Ribble Valley Borough Council

DELEGATED ITEM FILE REPORT - REFUSAL

Application No:	3/2014/0275/P
Development Proposed:	Four conservation rooflights (two on the front elevation, two on the rear elevation) at 14 Goose Lane Cottages, Goose Lane, Chipping PR3 2QF

PROPOSED FRONT ELEVATION (North)

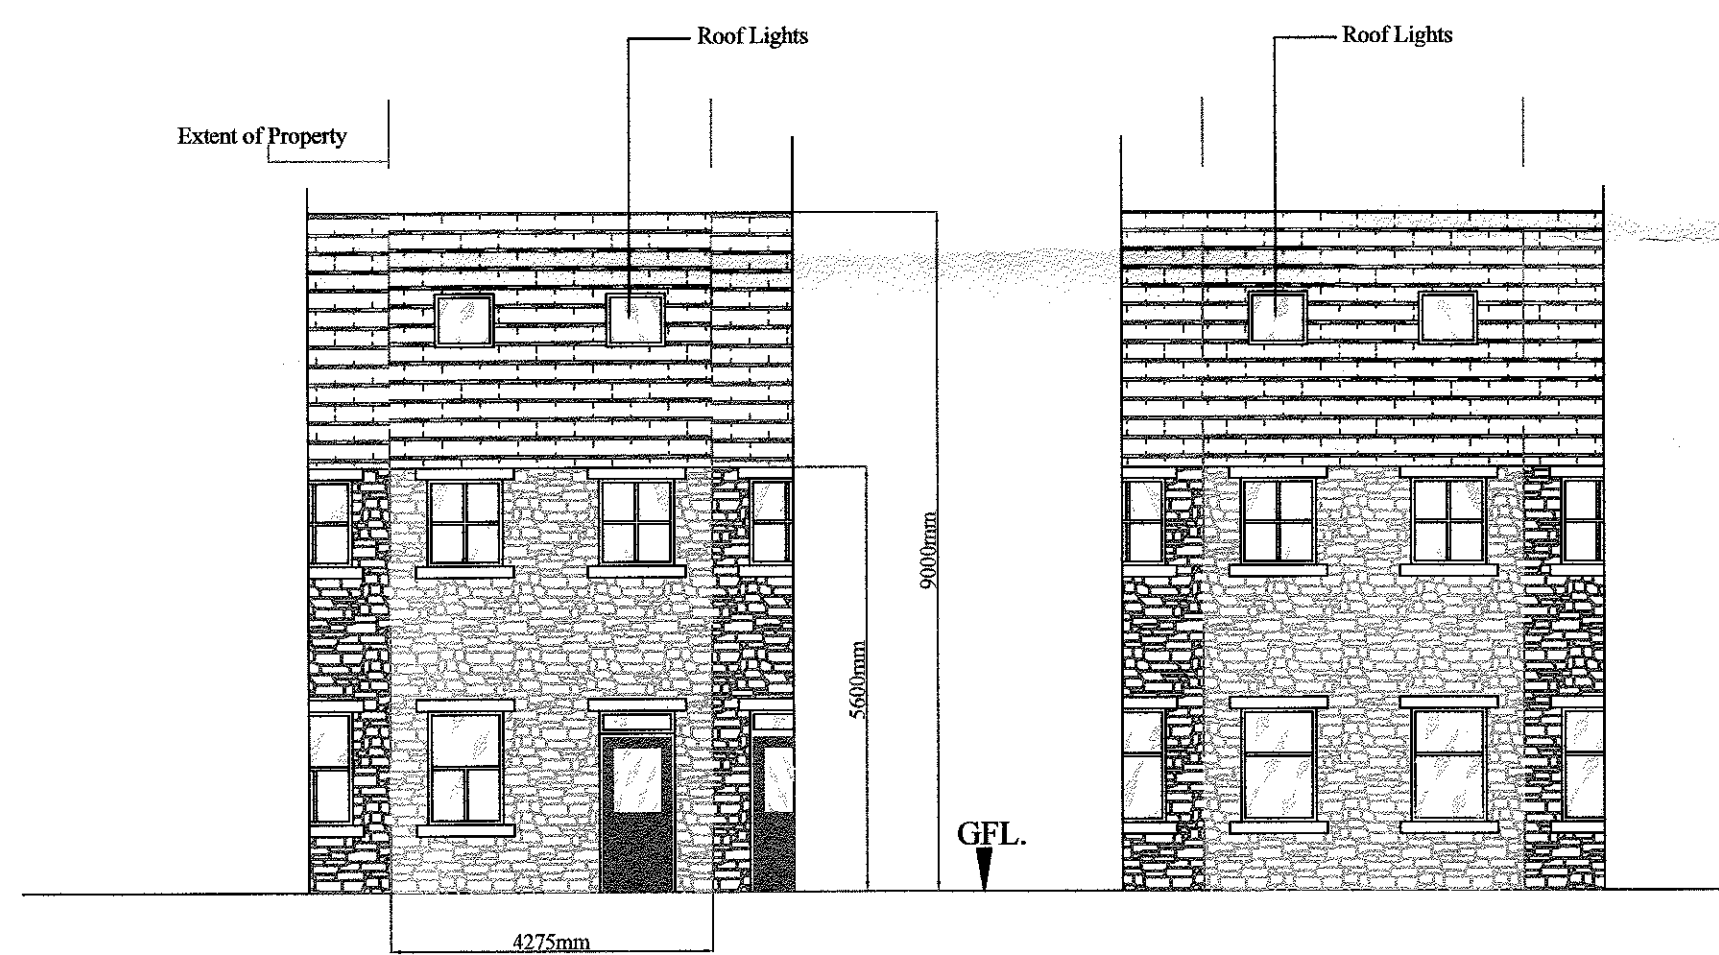
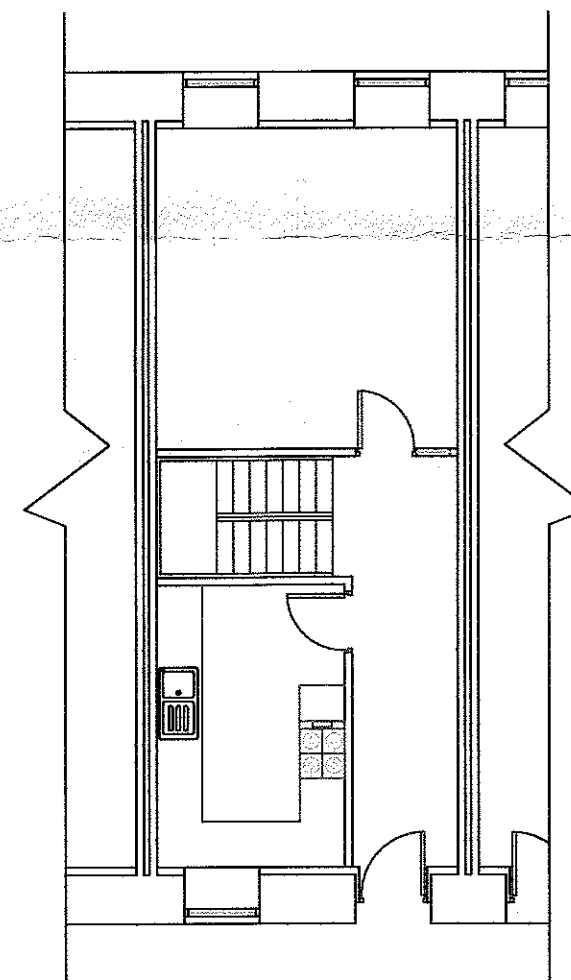
Permission is therefore sought to insert two rooflights within the front roof slope of the mid terraced property and insert two roof lights in the rear roofslope of the property.

The insertion of two roof lights on each of the two roof slopes, would result in a visual intrusion into the relatively unadorned blue slate roofscape of the building as a whole.

The further introduction of additional roof lights would add to the harm already caused by adding clutter to the relatively unadorned roofscape. This would be to the detriment of the intrinsic character of the former dairy building, a traditional building in the countryside, and the visual amenities of this part of the AONB when viewing the site from the surrounding countryside, contrary to Policies ENV1 and H17 of the Districtwide Local Plan and policies DMG1, EN2 and DMH4 within the emerging Core Strategy.
